Date: 13 December 2022

**Application by Drax Power Limited for an Order Granting Development Consent for  
the Drax Bioenergy with Carbon Capture and Storage Project**

**Procedural Decision following request to make changes to the application**

01-xx Amended Book of Reference Plot Number

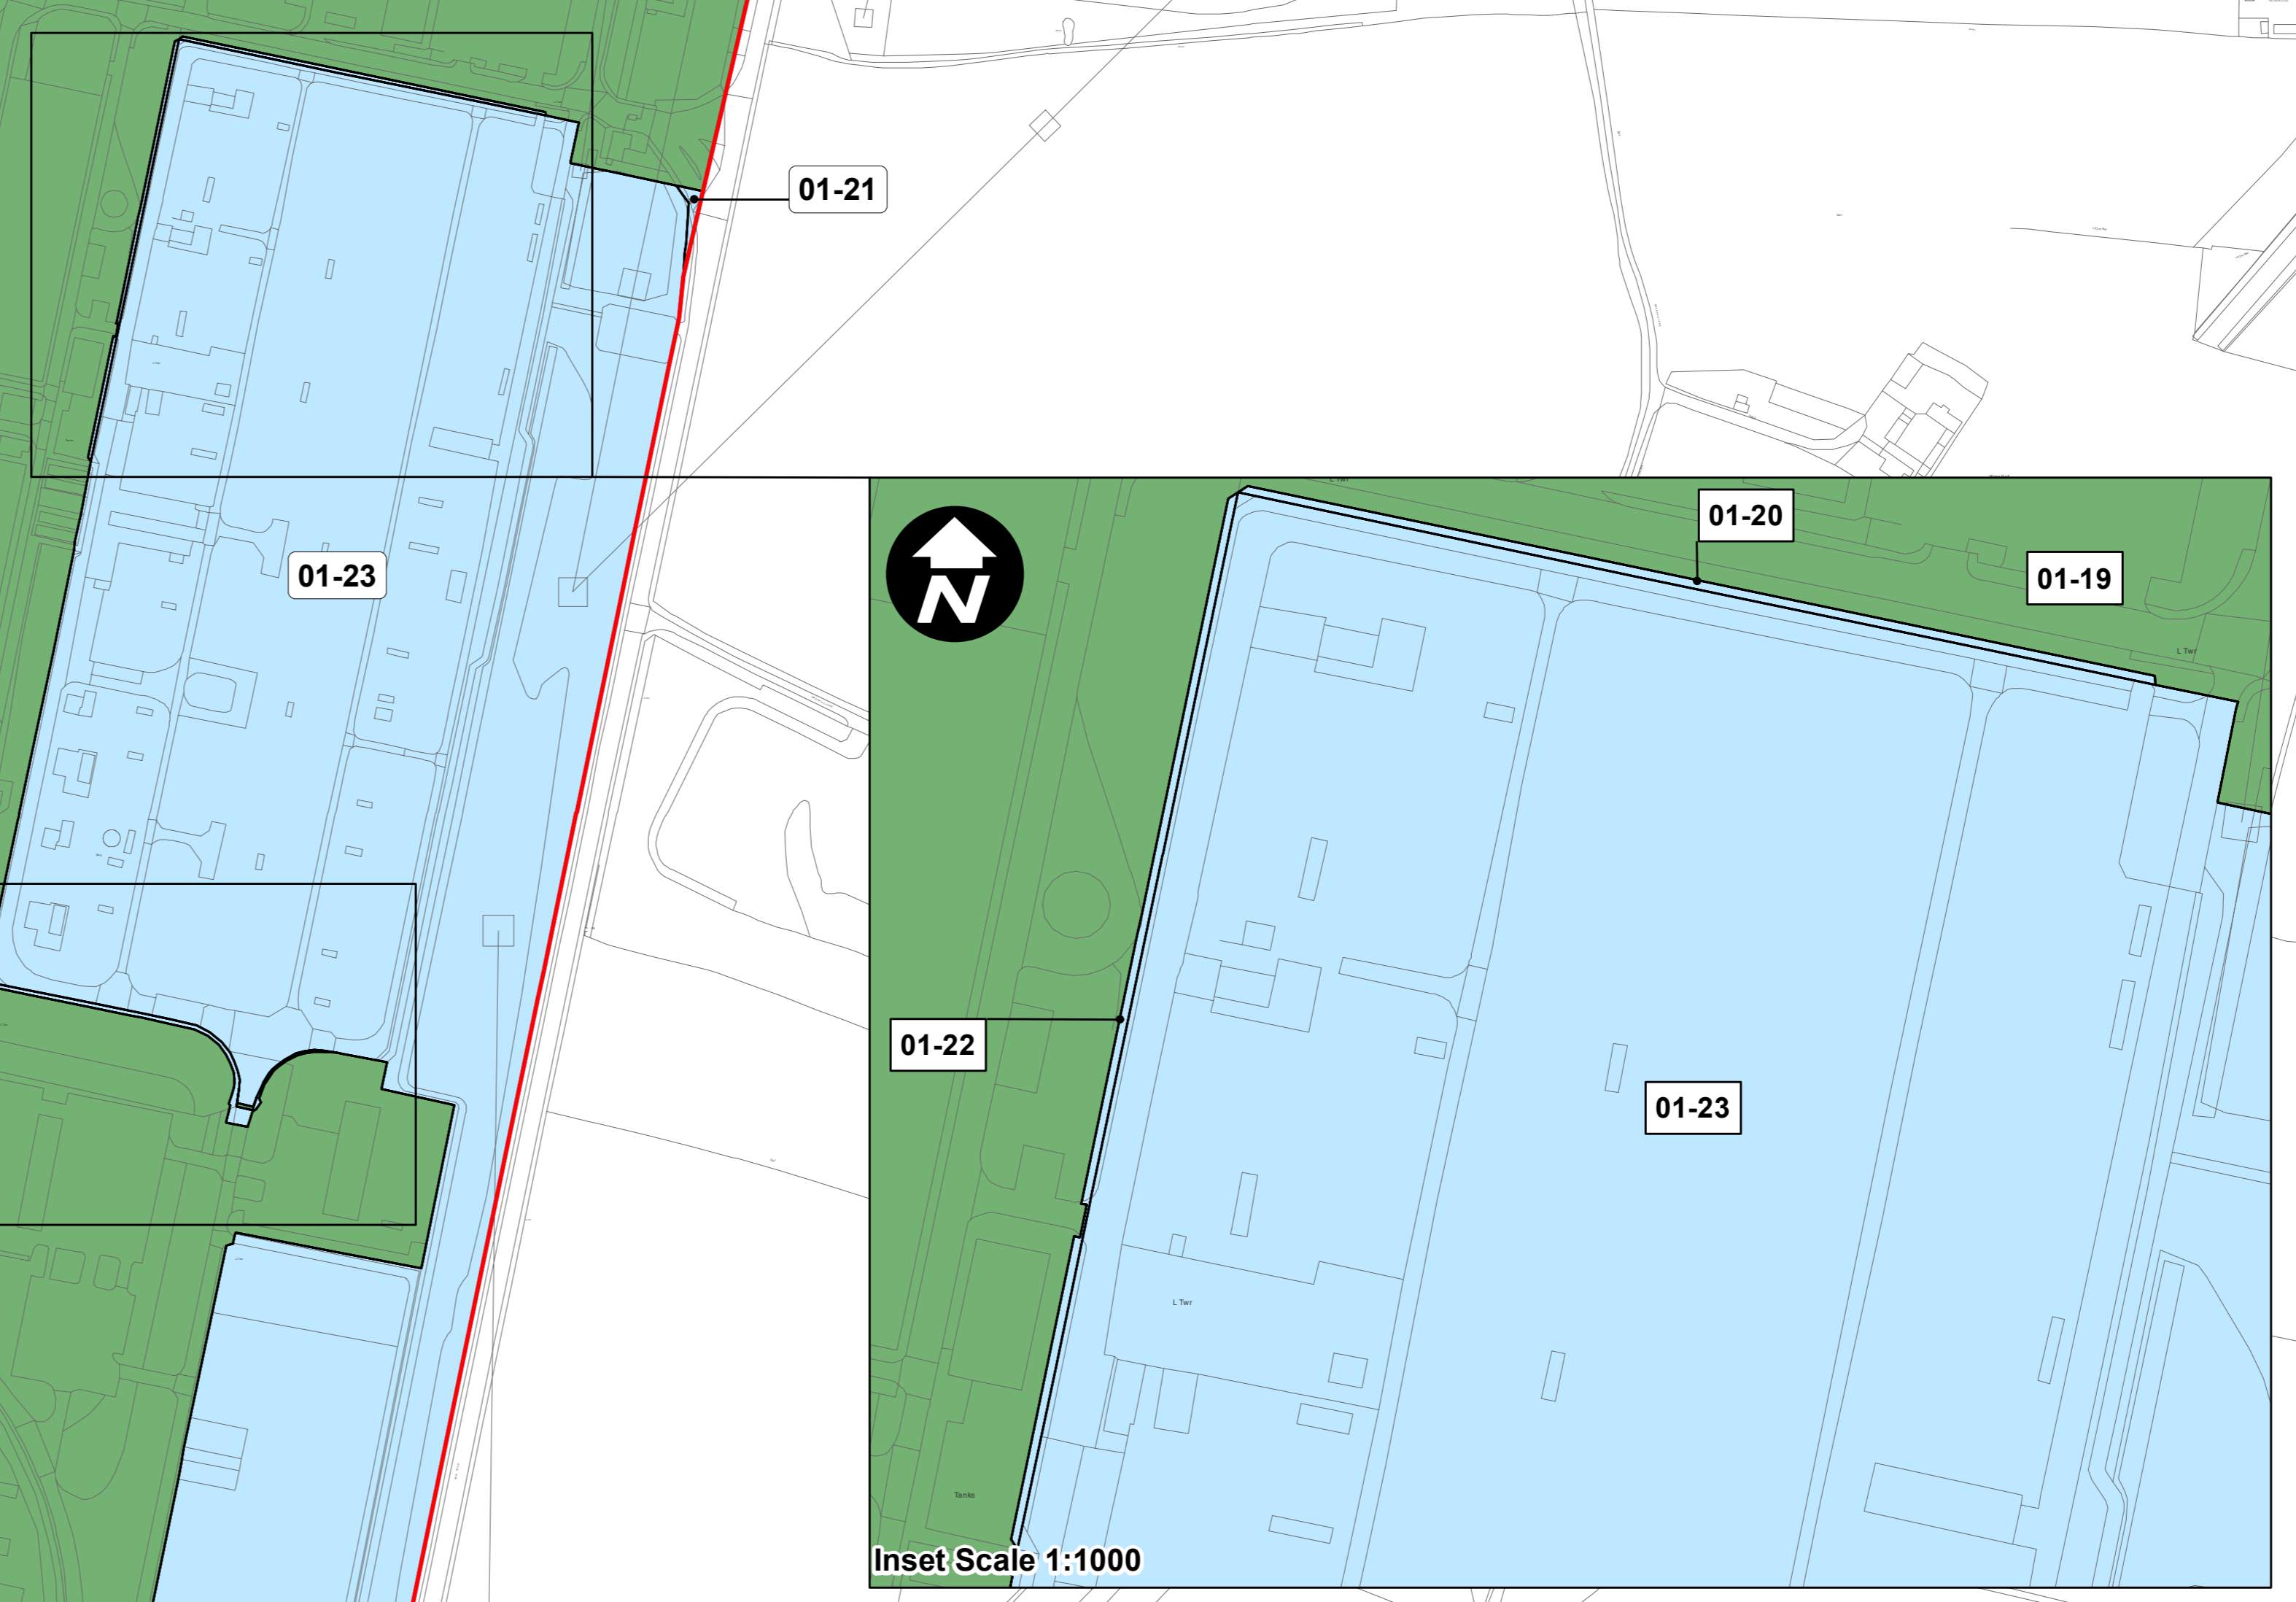
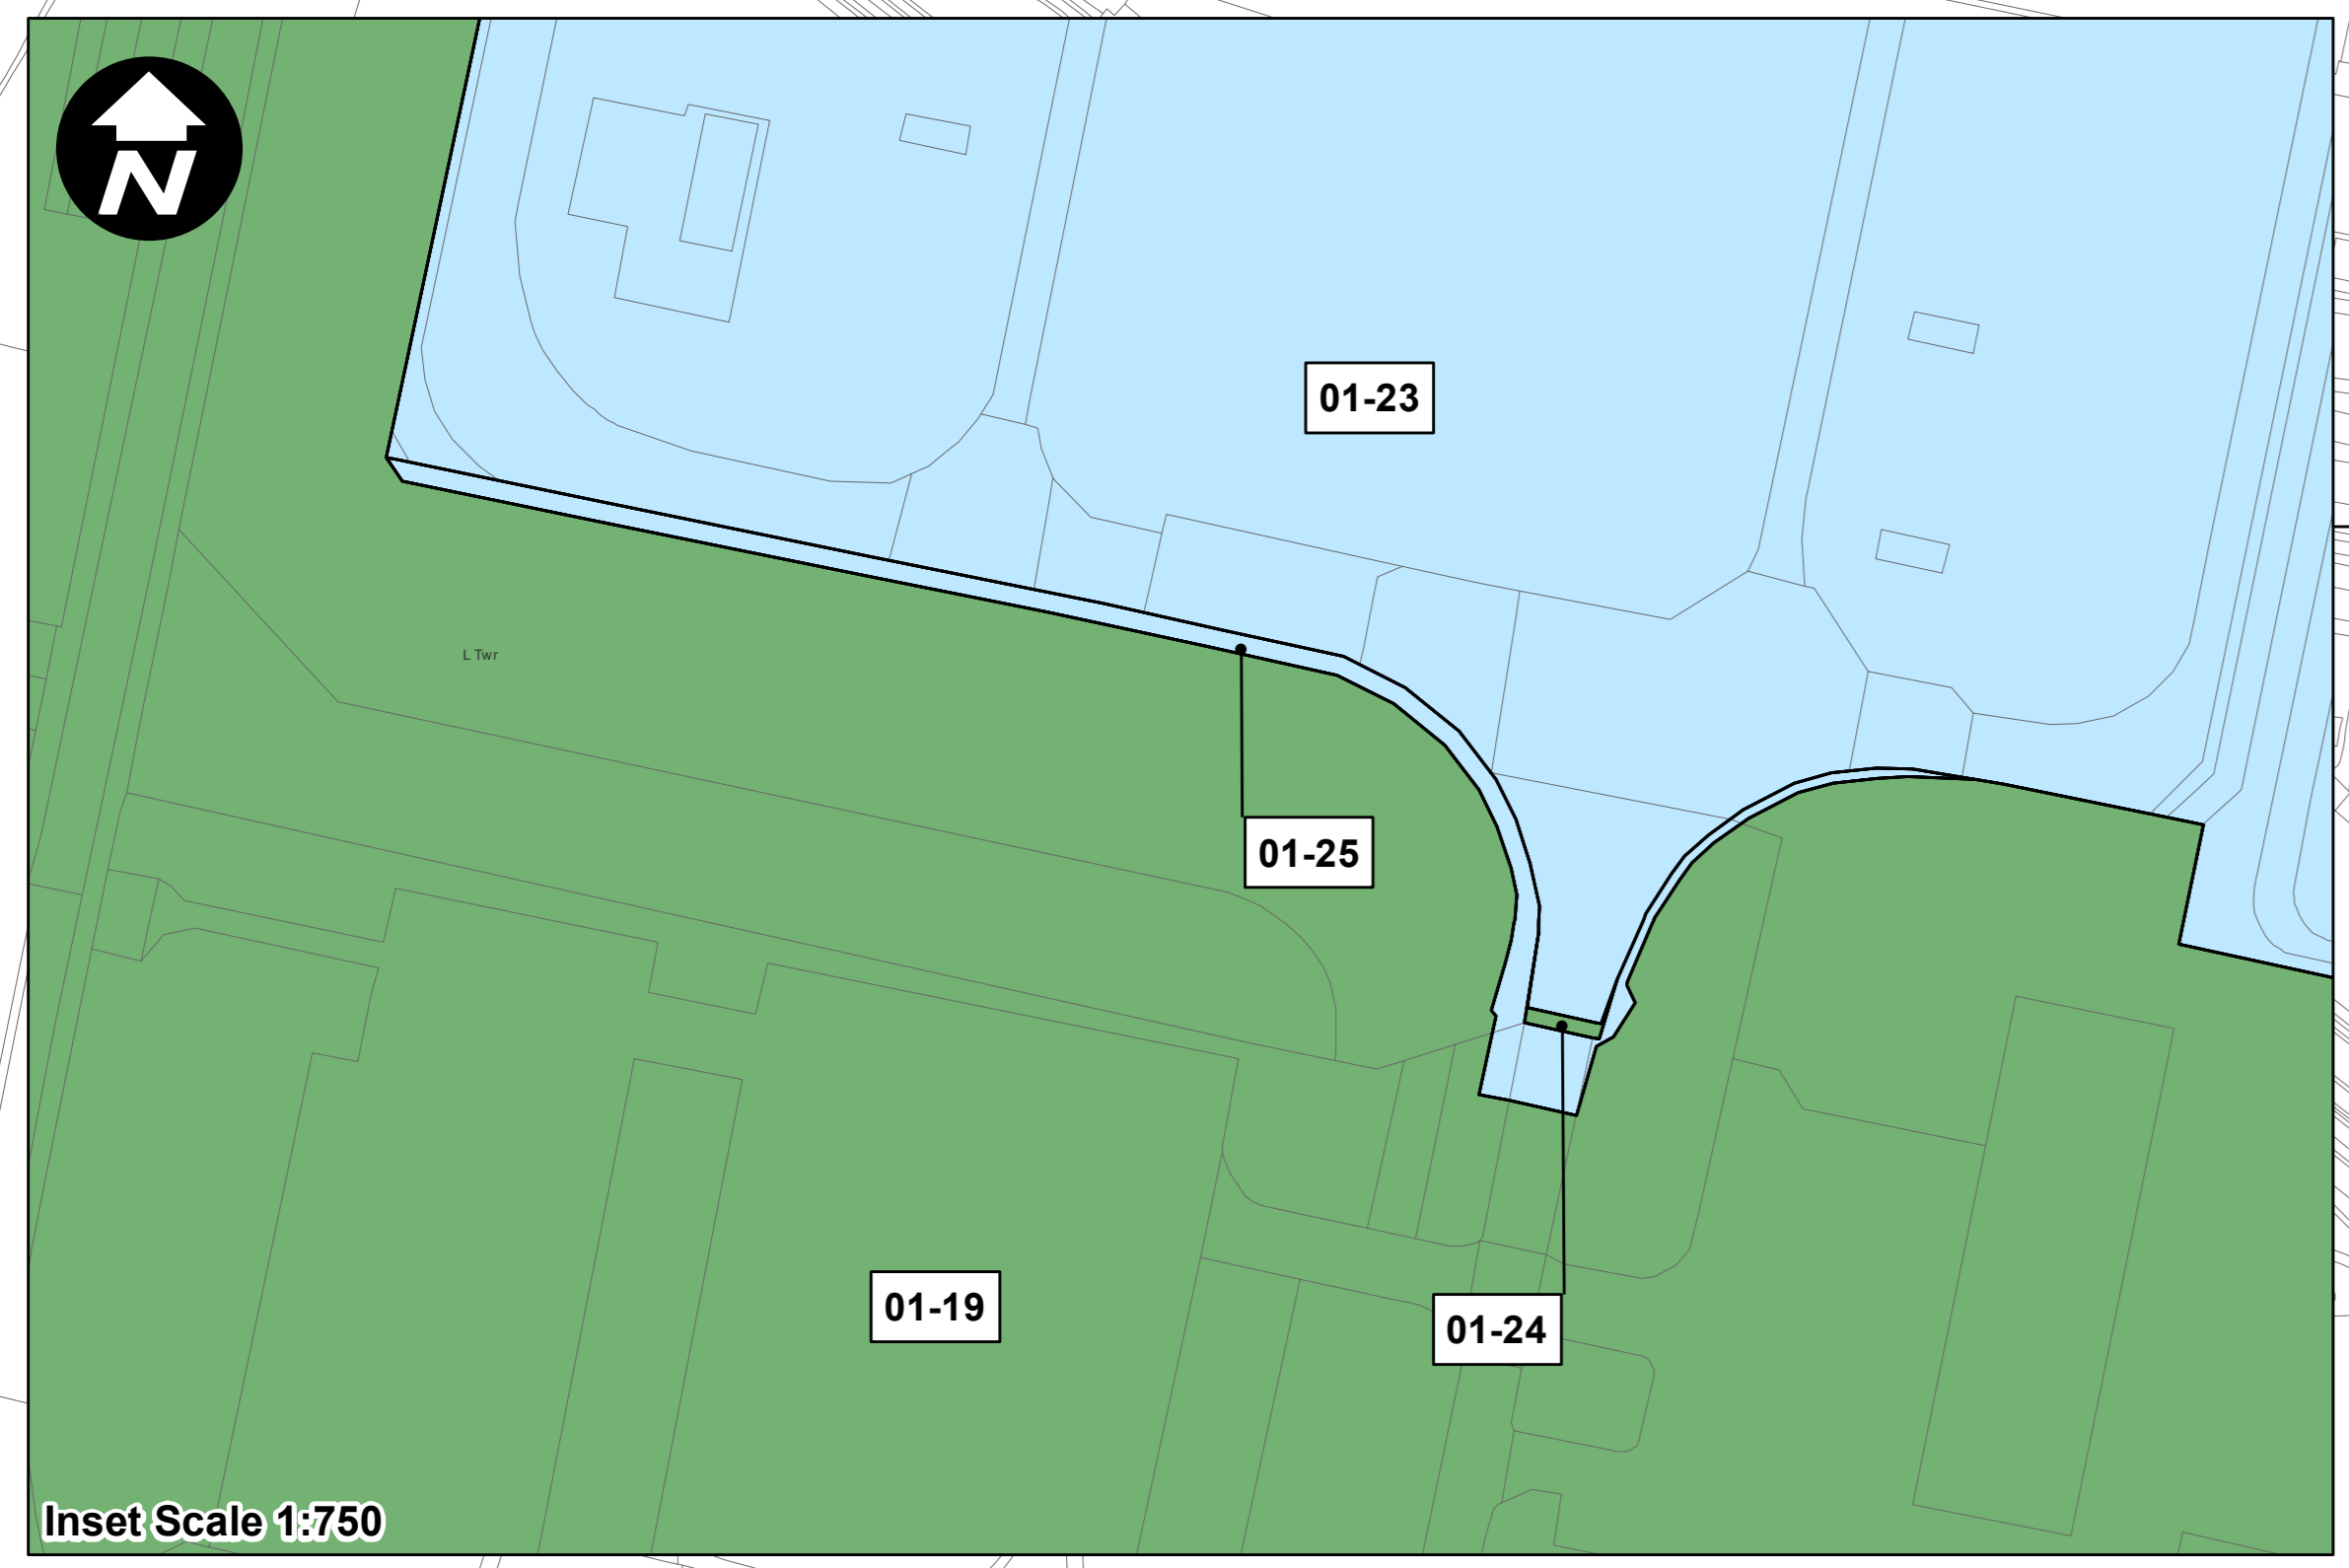
In reviewing the submissions for the change request, the ExA has made some observations on the Land Plans and Work Plans and would ask the Applicant to review and consider the below prior to the submission of its consolidated updates on 3 January 2022:

- Plots 01-82 and 01-92 on the Land Plans each appear to comprise two distinct sub-plots. Should each of these apparent sub-plots be individually numbered as a separate plot?
- Please provide an insert of 01-55 on the Land Plans for clarity.
- Should plots 01-47, 01-78, 01-80, 01-114 and 01-115 on the Land Plans be shaded green?
- Please ensure that a Key Plan in accordance with Regulation 5(4) of the Infrastructure Planning (Applications: Prescribed Forms and Procedure) Regulations 2009 is submitted with the updated Land Plans, as this is omitted from the Land Plans submitted with change request.
- Should centre lines be shown for Work No. 8 on the Works Plans given it relates to overhead lines?
